**From:** Louise Sherwell [<mailto:louisesherwell@warwickshire.gov.uk>]  
**Sent:** 23 January 2018 16:53  
**To:** Planning  
**Cc:** Matthew Parry  
**Subject:** Re: 17/02534/OUT - Land North Of Bicester Avenue Garden Centre Oxford Road Bicester

Regarding the above application, I have read the Ecology chapter of the ES submitted together with the associated technical appendices, and viewed the proposed plans. At the current time we would recommend refusal/deferral of the application and consider there is insufficient information within the ES to fully assess the impacts of the proposals on certain protected and notable species and to ensure no net loss biodiversity as a result of the development. We would be happy to provide further comments and recommendations once the further information has been provided as requested, including suggested condition wording. We have the following comments on the application:

CLIENT
Illustrative Masterplan

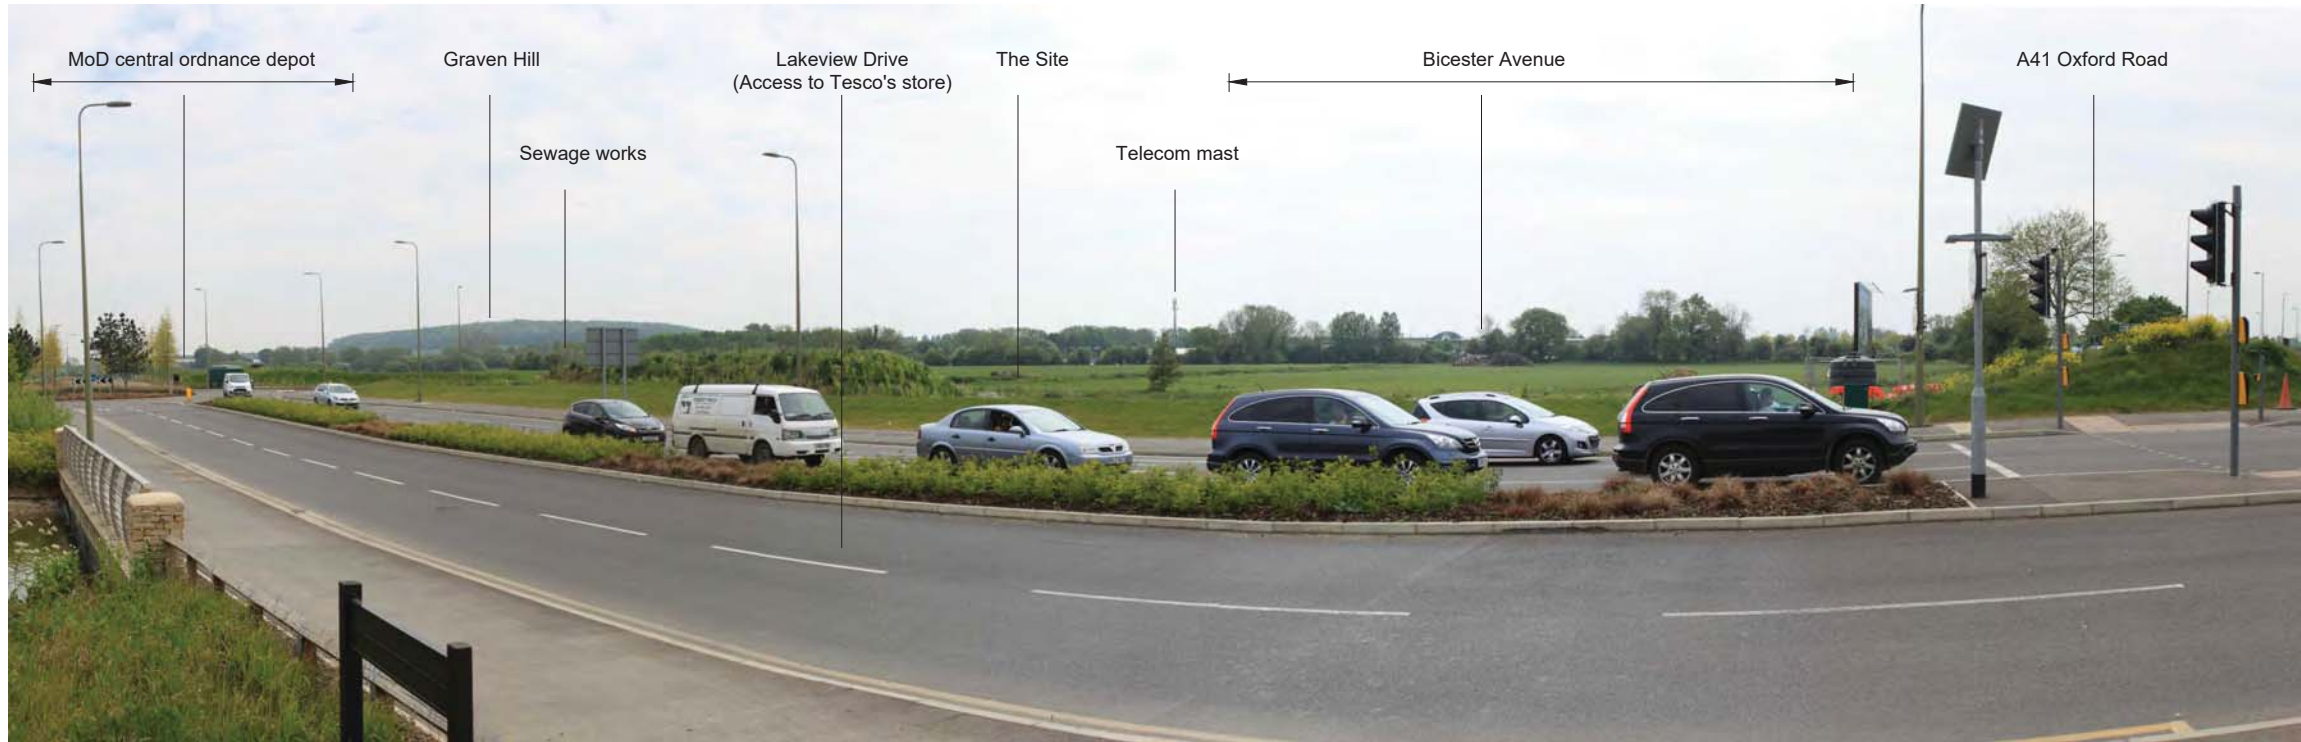
The proposals shown on the Illustrative Masterplan indicate tree/shrub planting and areas of open space, however there is little information regarding the types of habitats proposed within the open spaces, and the D&A statement proposes intensive management, which is not likely to contribute to biodiversity on site. We also have concern that a number of existing hedgerows on the boundaries of the site (including along the A41) and the central ditch D1 appear proposed to be removed. The PEA highlights that the hedgerows on site are all Section 41/ UK BAP priority habitats and the ditch is the most biodiverse habitat on site. Therefore I would strongly recommend the hedgerows and the ditch are retained and protected within the layout of the development. If this is not possible, appropriate mitigation measures will be required to address the loss.

The ES also does not consider any potential impacts of the development on the existing hedgerows or trees, many of which have suitable bat roost features, as the ES assumed the protection of hedgerows to BS 5837:2012. We have concerns with this, as according to the illustrative masterplan hedgerows and trees are proposed to be removed. Therefore this should be clarified and assessed accordingly should they be proposed to be removed.

The strip of wildflower meadow where skylark plots are proposed as mitigation for loss of the skylark nesting habitat is not considered to be suitable, as according to the indicative masterplan this location is adjacent to a building, car park, and is proposed to be tree/shrub planted. Skylarks are ground nesting birds requiring open space to nest, away from shrub and tree cover. The open fields to the east of the site at present would be more suitable for skylark, if there is scope for long-term management of this area. However given the skylark records in the local area it is possible there may already be skylark nesting in these fields. Further information will therefore be required **prior to determination** to assess the impact of the proposed development on skylark and to inform mitigation. This should include further surveys to identify the impact of the development on skylark and to identify location(s) for off site compensation - either within the blue line boundary, or if surveys reveal skylark are already present, via an appropriate contribution or a management scheme for a site elsewhere in local area. Skylark plots have been proven to work well on arable, but I would suggest that a more permanent habitat (rough grassland) would be preferable. This option does not require skylark plots but the creation of rough grassland and then management by light grazing or by rotational cutting (one third per year).

Figure 11.1: Habitat Plan

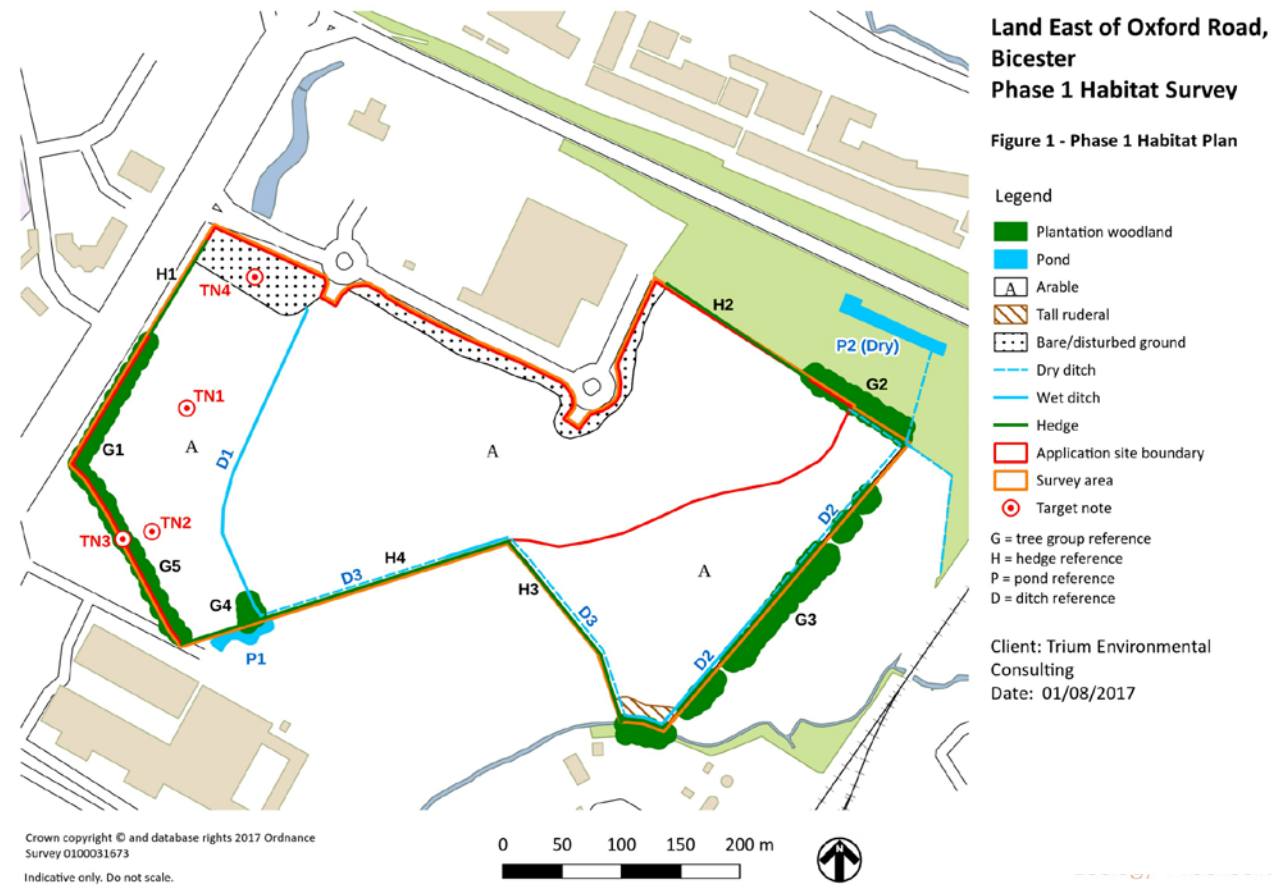
The phase 1 habitat survey was undertaken during May 2017 which is within the optimal time of year for habitat surveys. The site largely comprises an arable field (under a rye grass crop). However in the recent past (according to aerial photography 2014-5), the western most field comprised of rough grassland. This area was identified in 2014 via the CDC Habitat and Land Use Study as rough grassland and also possible Section 41/UK BAP priority grassland habitat. From aerial photography, the hedgerow along the A41 also appears to have been cut back significantly. A log pile and spoil heap were present in the north of the site. Given as this habitat has been cleared and is sown with rye grass it is not possible to determine the value of this area of the grassland. However it is still possible to carry out a Biodiversity Impact Assessment (BIA) calculation based on the value of the habitats at present.

Figure 11.2: Proposed Bat Corridors

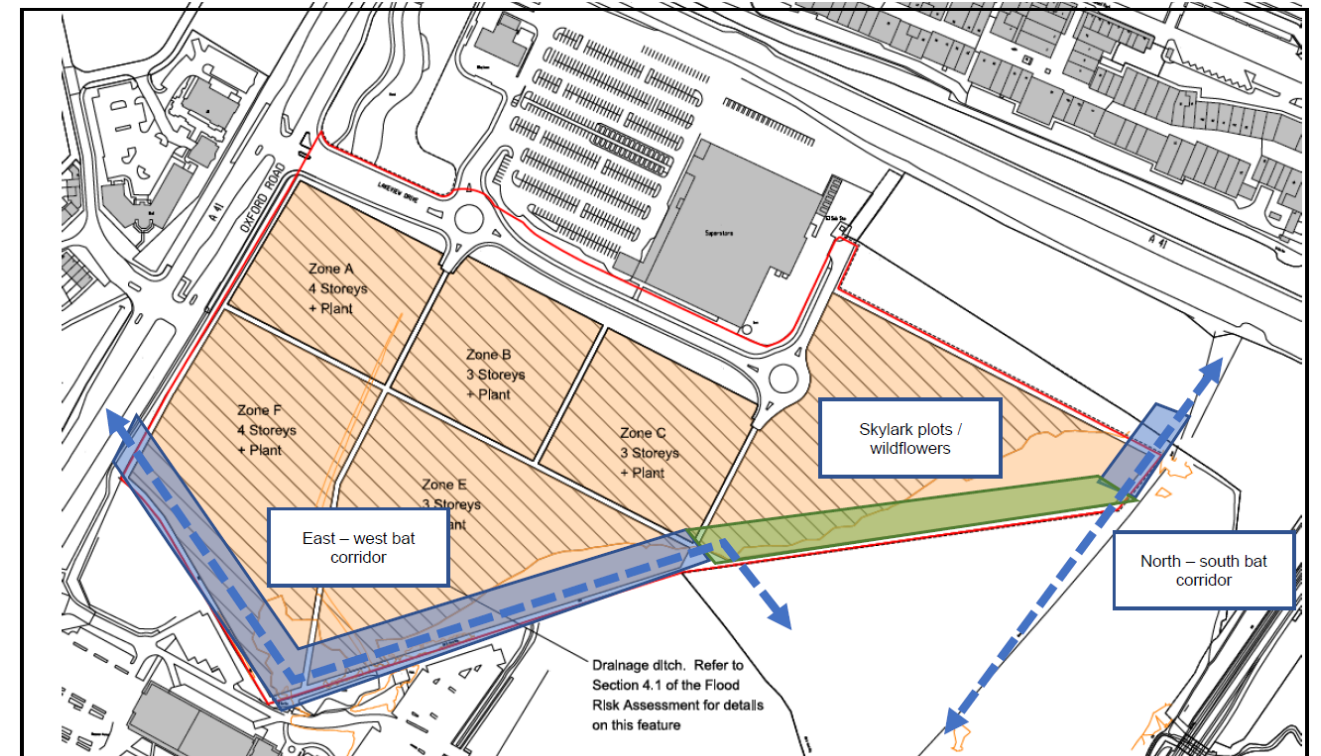
North-south and east-west bat corridors are proposed and are proposed to minimize light spill or a maximum of 1 lux at ground level. I welcome these proposals and would recommend that the detailed external lighting scheme be secured by condition of any approval granted.
